Application for Planning Permission

Development: Change of use of A1 buildings & yard to B8 use with elevational alterations, including solar panels and changes to the parking layout. This application is in CIL Zone 4 (Zero Rated) as other development.
Location: East Preston Depot Station Road East Preston BN16 3RE

DRAWING TITLE
Floor Plans - Building A
As Existing

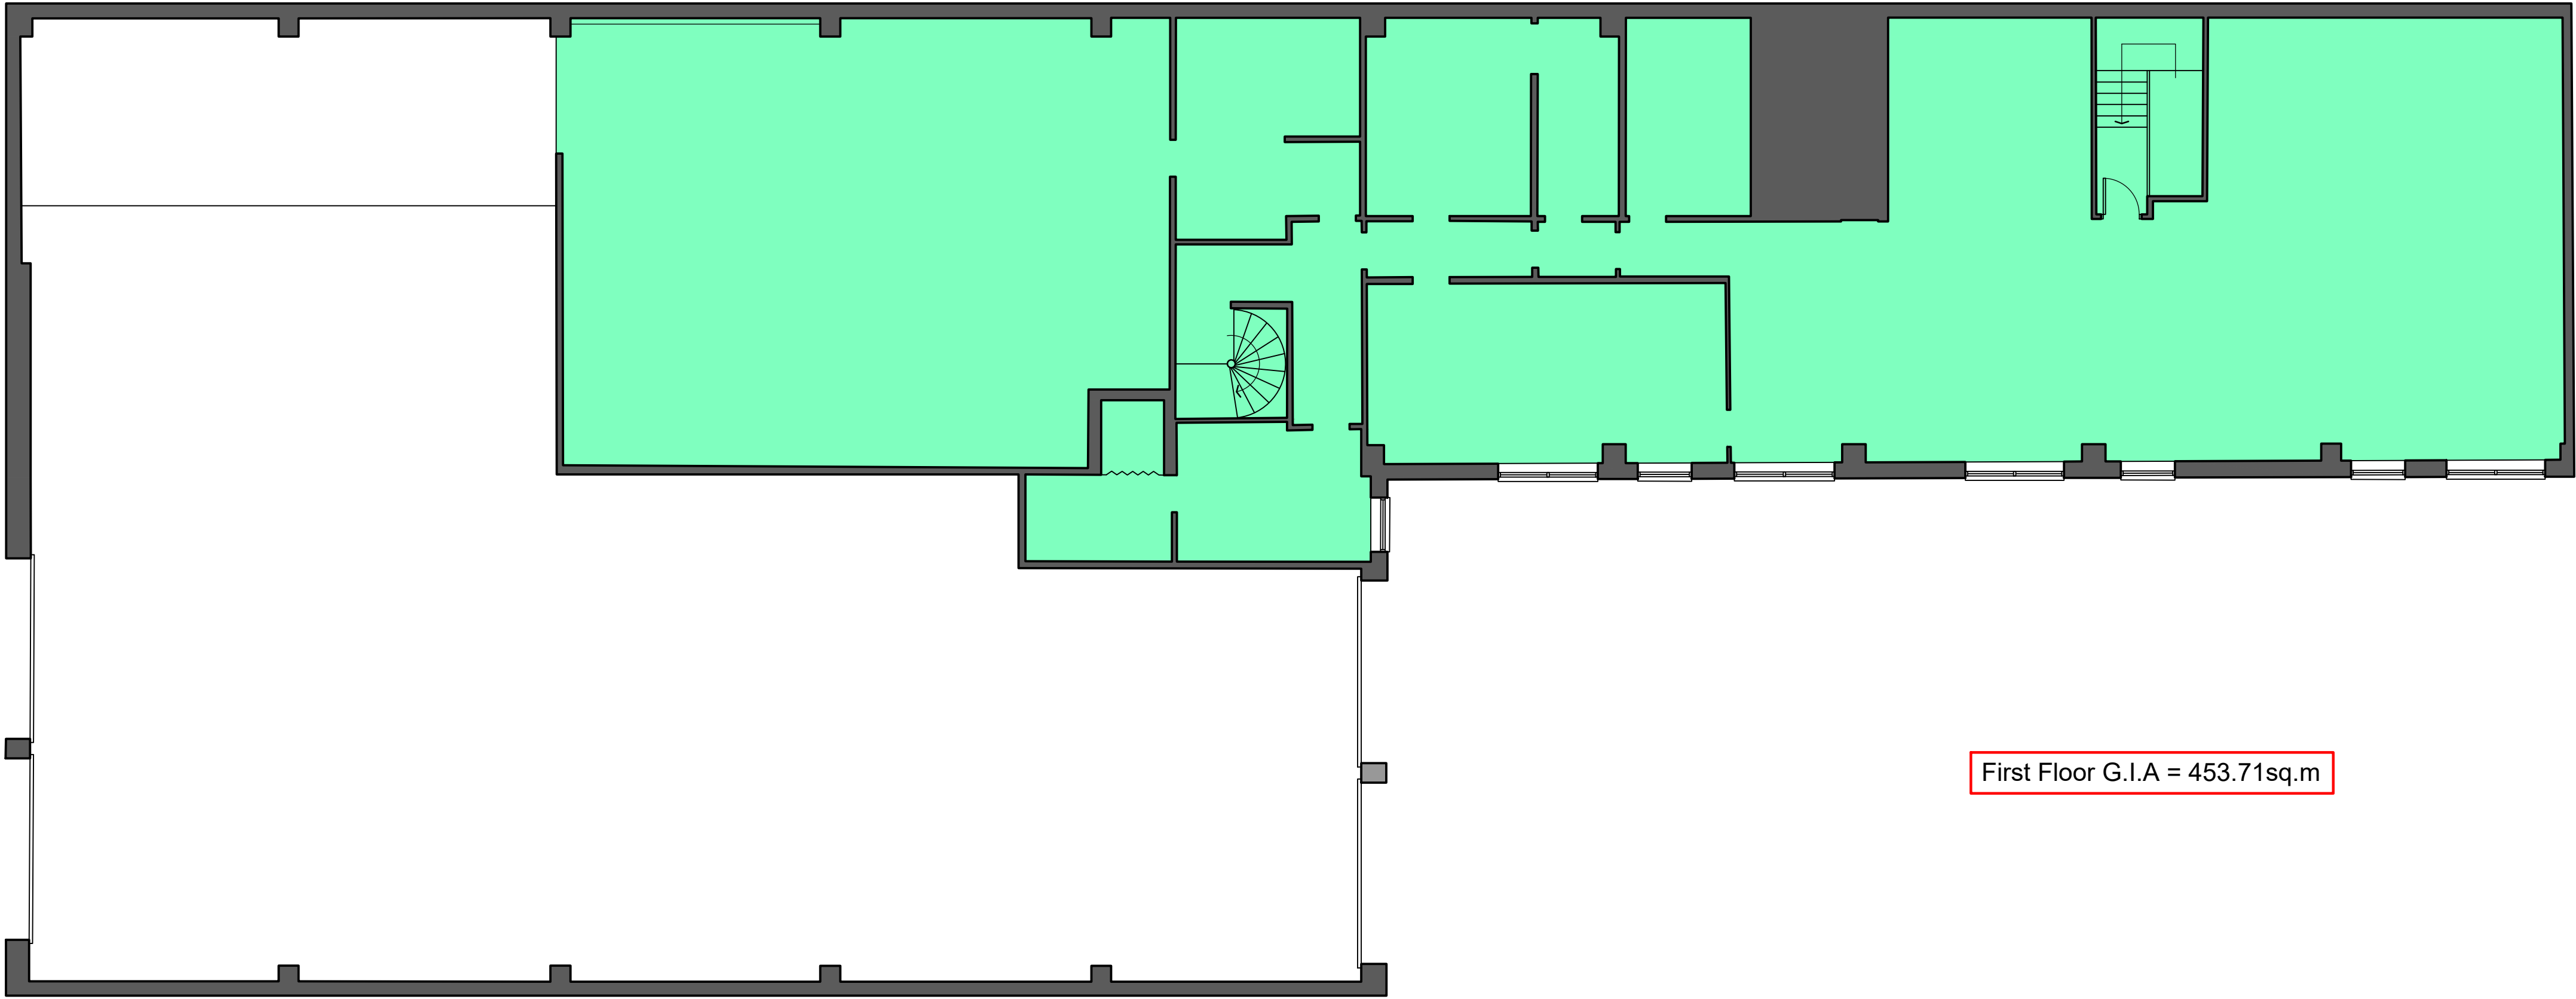
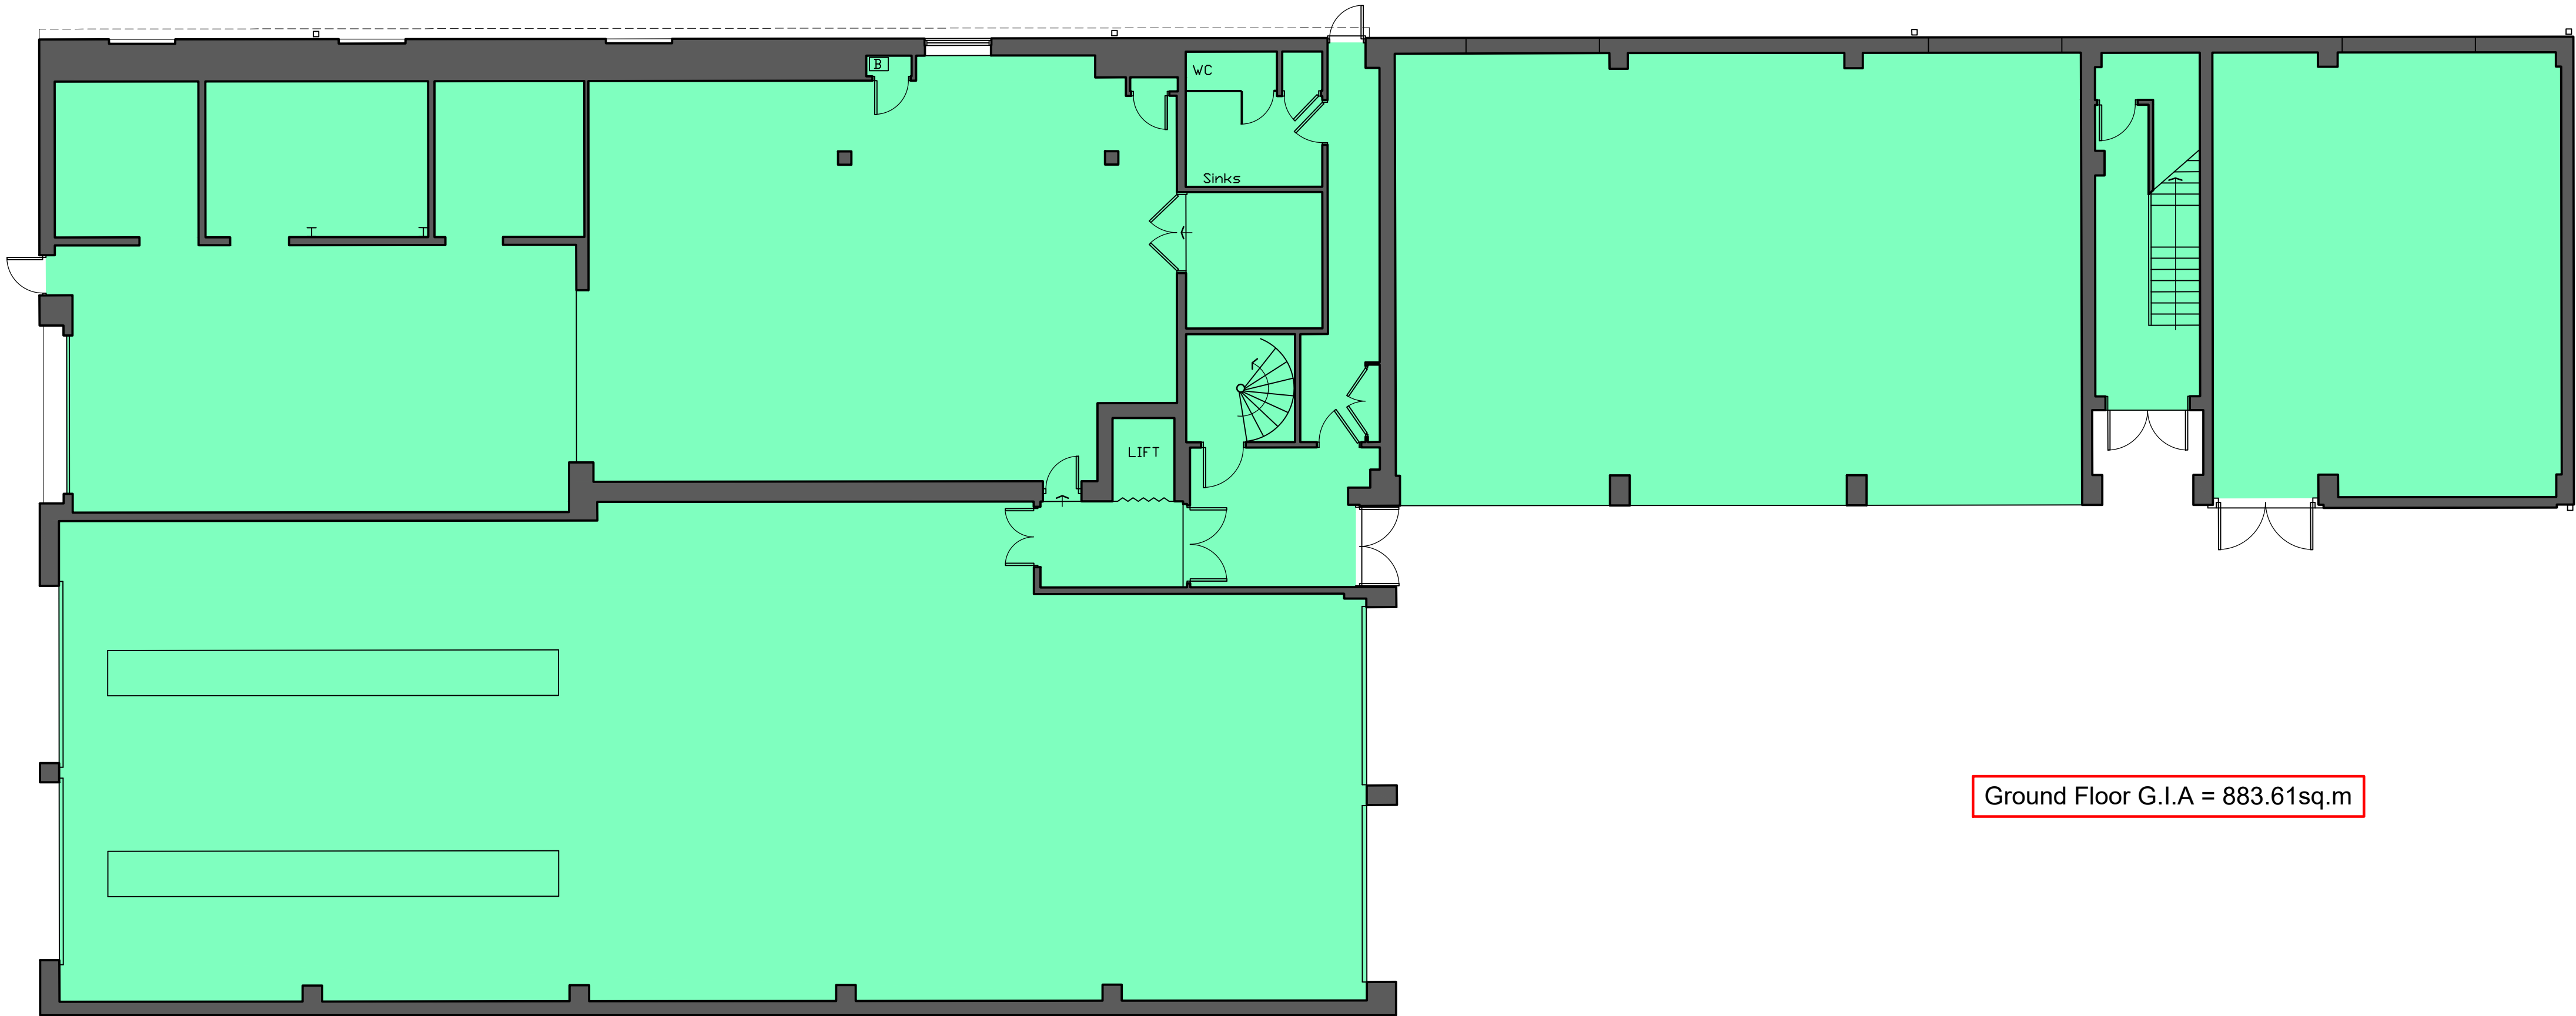
The existing north elevation and first floor plan do not accord. Please amend accordingly.
